RE: 14 Distribution Drive, Orchard Hills – Request for Additional Information - Transport Statement (SSD18204994)

TABLE 1 RESPONSE TO SEARS – SSD 18204994

ENTRY (B-DOUBLES)

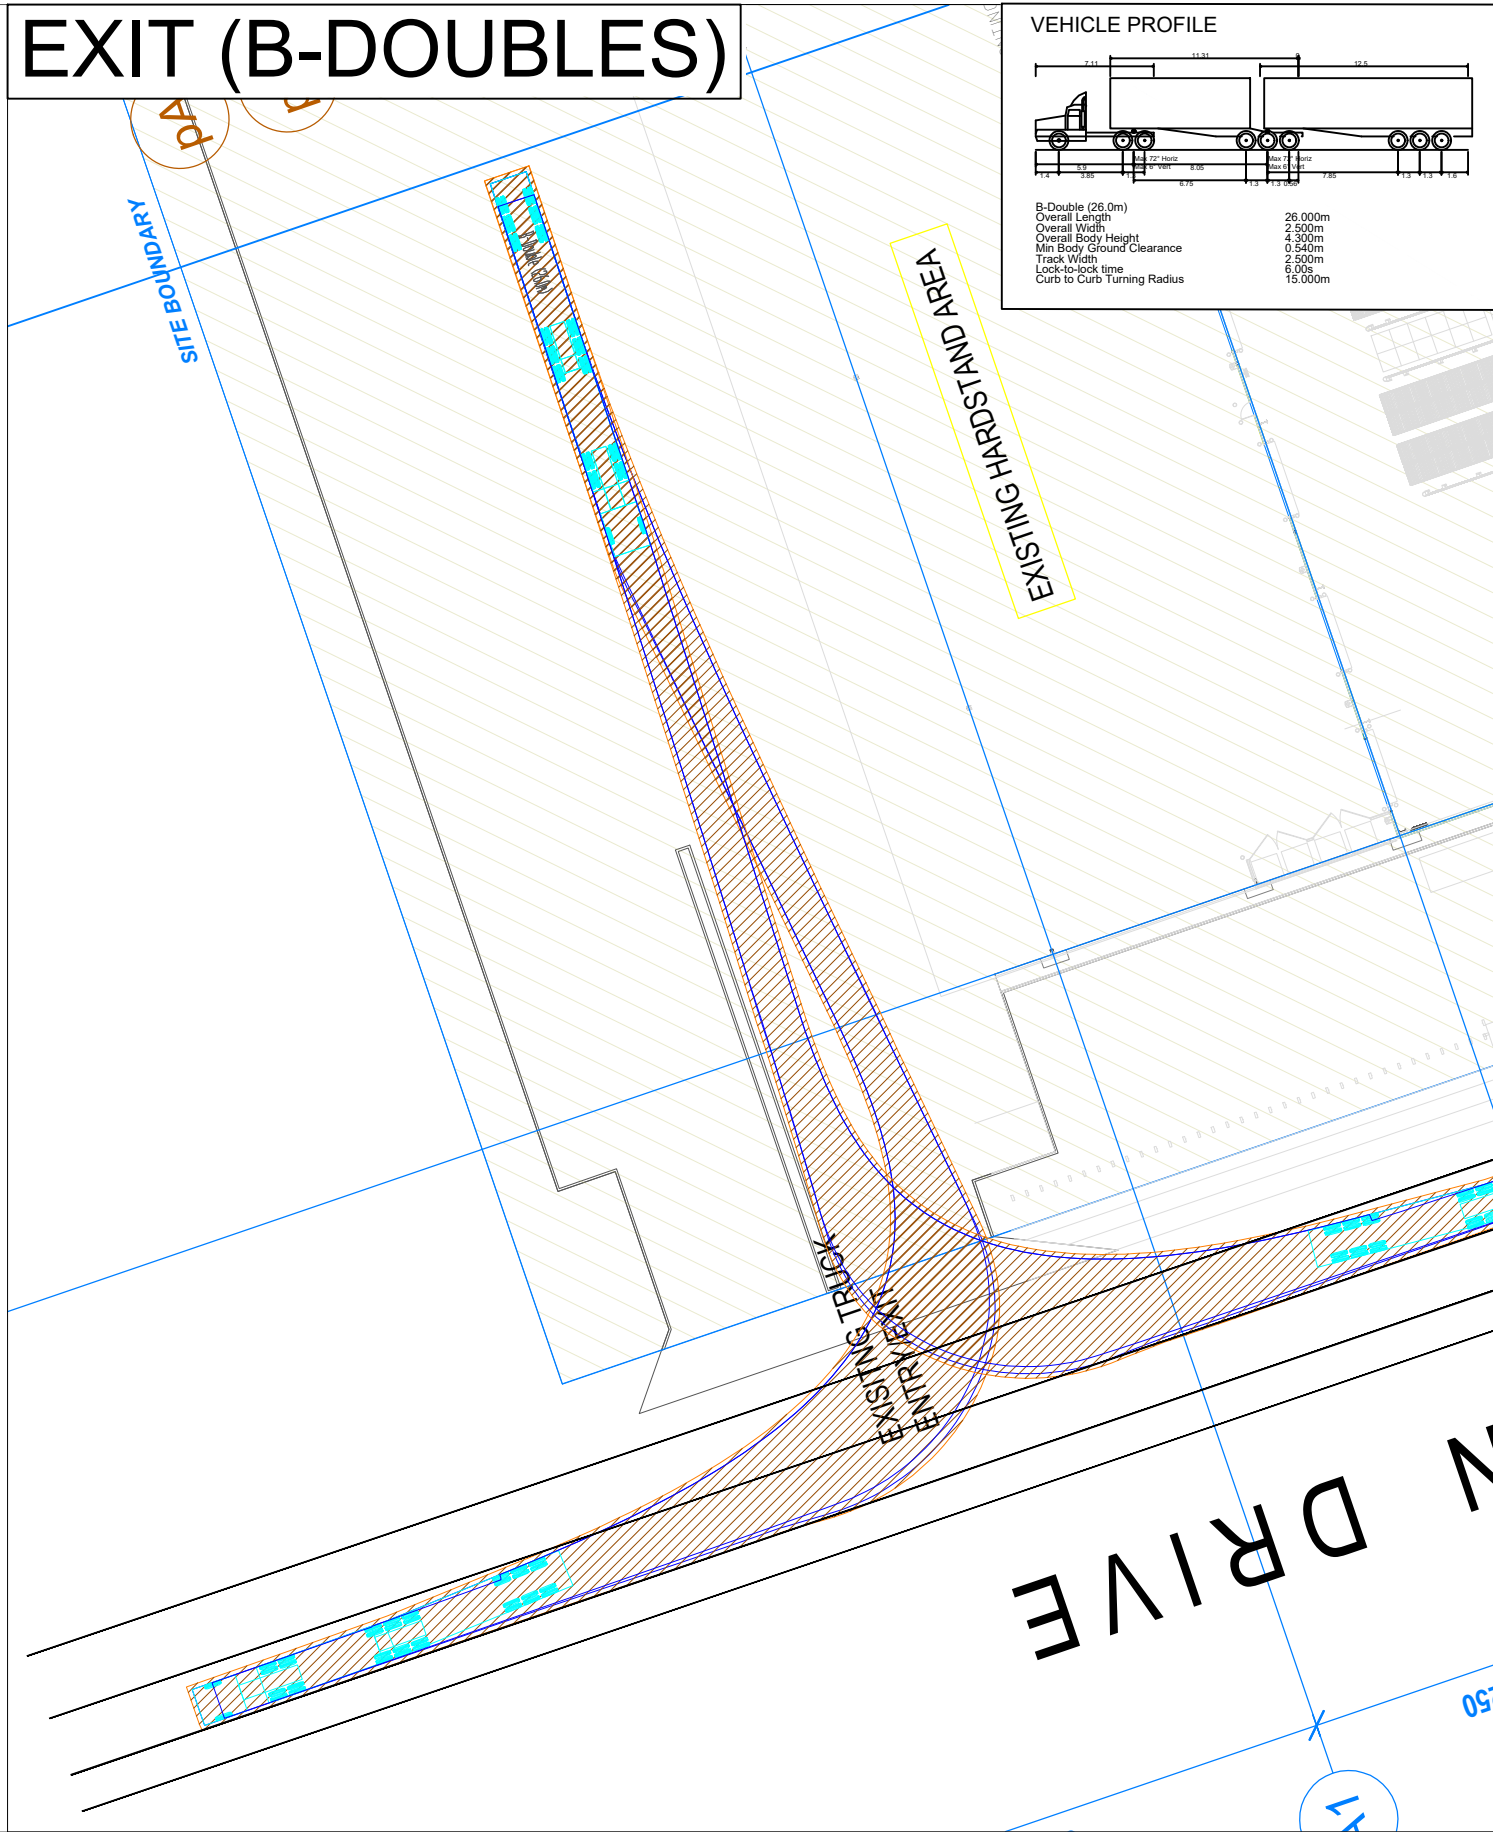
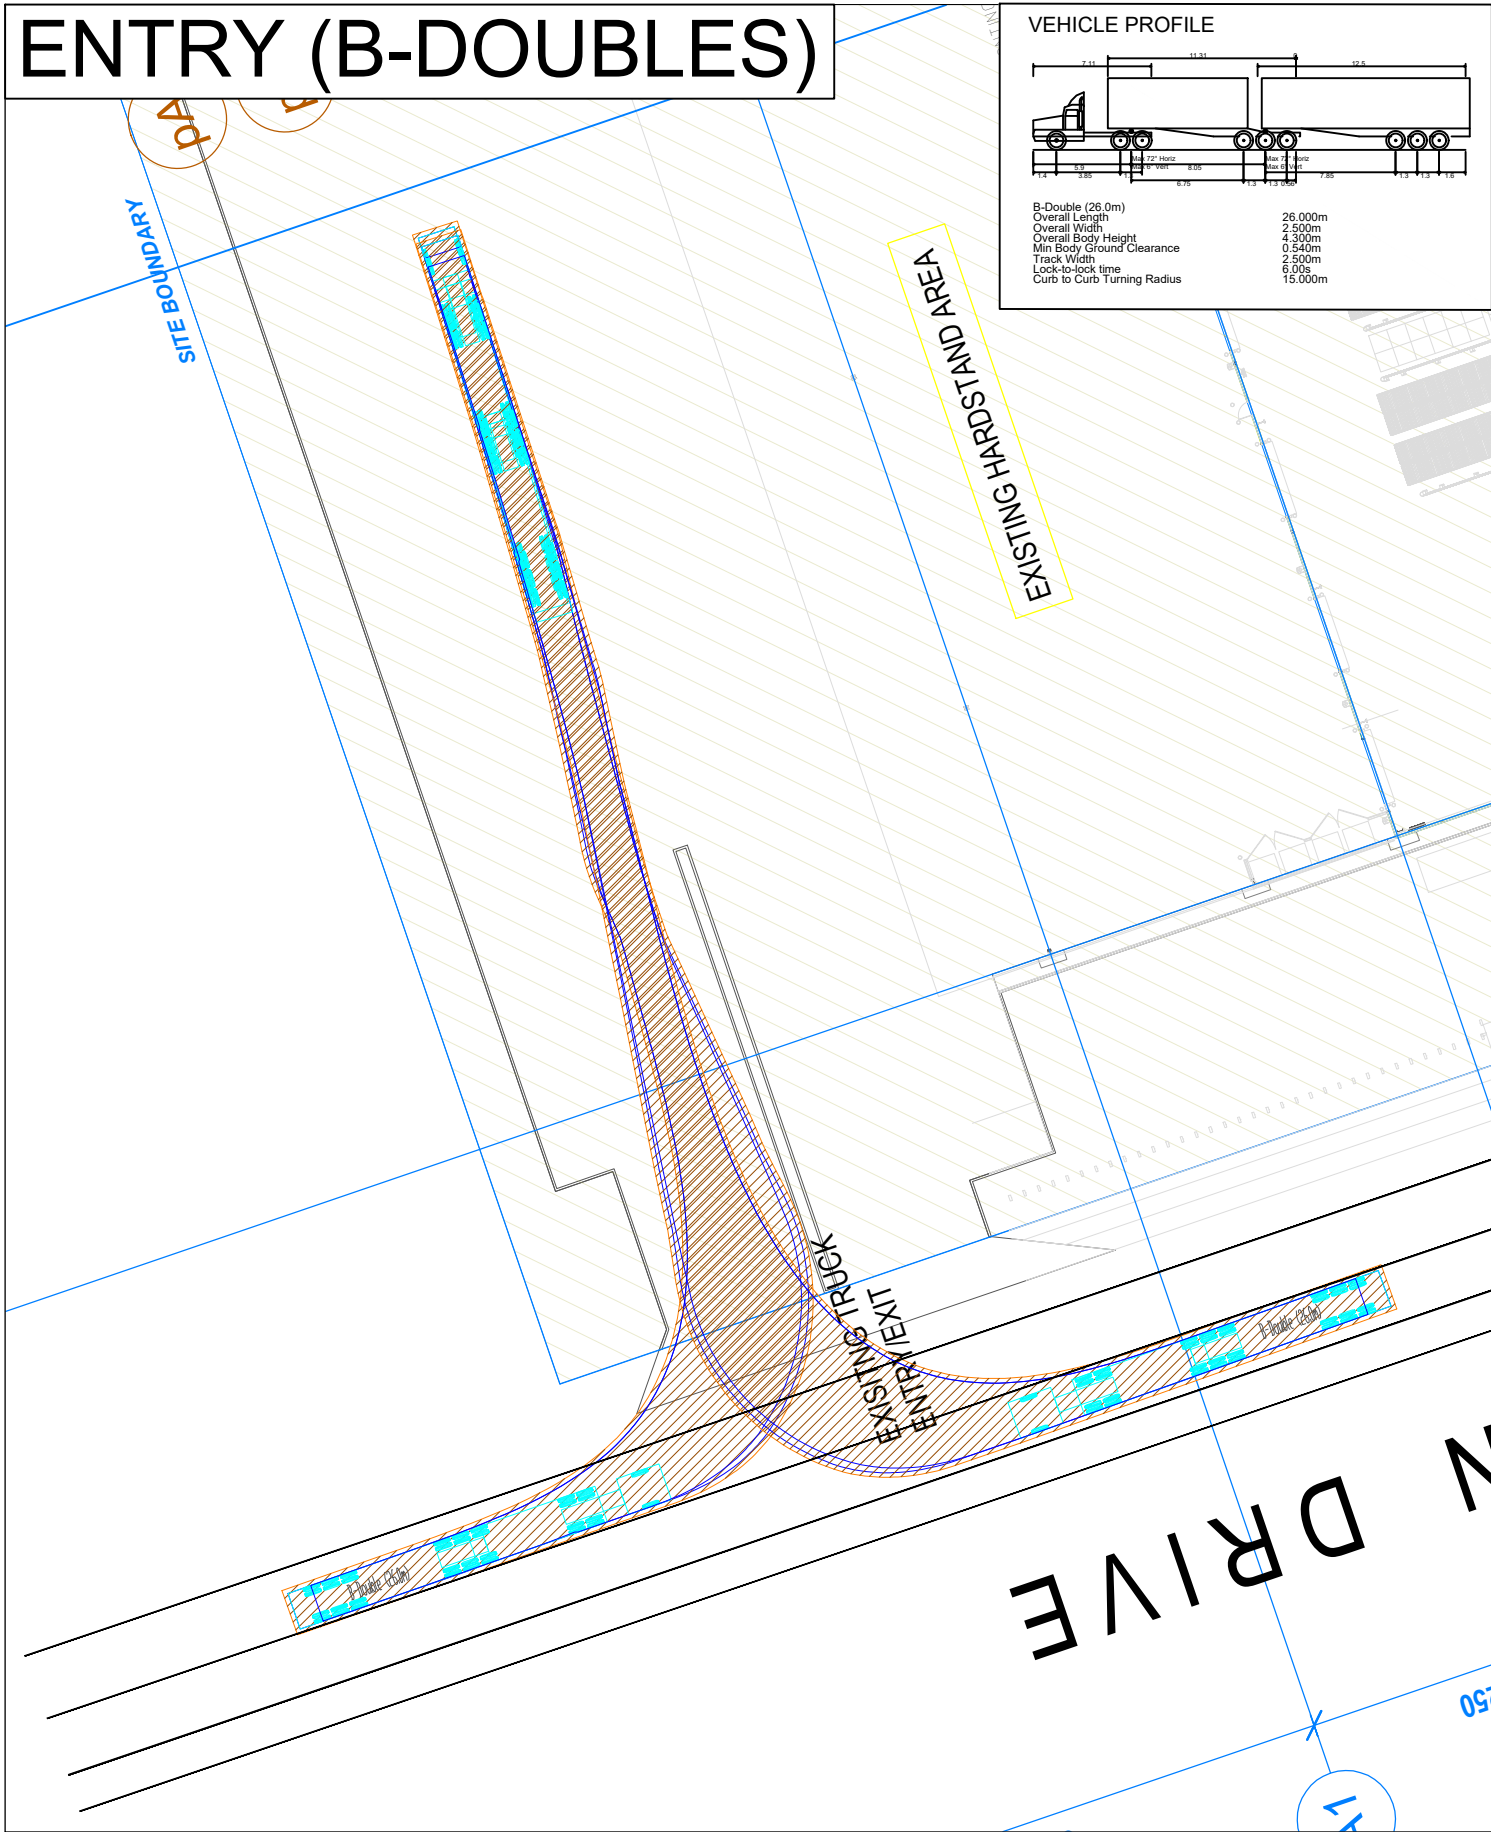
7	<p>Mamre Road is an approved PBS 2B route and large industrial development within Western Sydney Employment Area should consider PBS 2B as the design vehicle. However, the Transport Assessment (TA) site accesses and internal hardstand areas have been designed to cater for trucks of up to 26.0 metres B-doubles.</p> <p>The TA needs to graphically demonstrate site accesses and internal hardstand areas have been designed to cater for trucks of up to a 30m PBS Level 2B vehicle.</p>	<p>Refer to Attachment C which showcases the swept path assessment with the 30.0m PBS Level 2B vehicle (30.0m Super B-double truck) as the chosen design vehicle.</p> <p>The swept path assessment indicates that the 30.0m Super B-double truck can enter and exit the Site as required. Furthermore, the swept path assessment also demonstrates the 30.0m Super B-double truck manoeuvring through the hardstand area.</p>
8	<p>The TA has acknowledged two RSDs where B-doubles will be need to be reversed to unload from the rear. As the rear trailer is in the way, the front trailer (or A-trailer) of a B-double is typically unloaded by de-coupling the trailers, or jack-knifing the combination.</p> <p>The TA needs to clarify whether a de-coupling area is required so that both the 'A' and 'B' trailers can be unloaded from the rear for the two RSDs which require Bdouble reverse movements</p>	<p>Refer to Attachment C which shows the proposed de-coupling area on AG03 and AG04. The decoupling zone is in line with the relevant AS requirements.</p> <p>Furthermore, a swept path analysis has been undertaken to indicatively show the operation of this zone as well.</p>
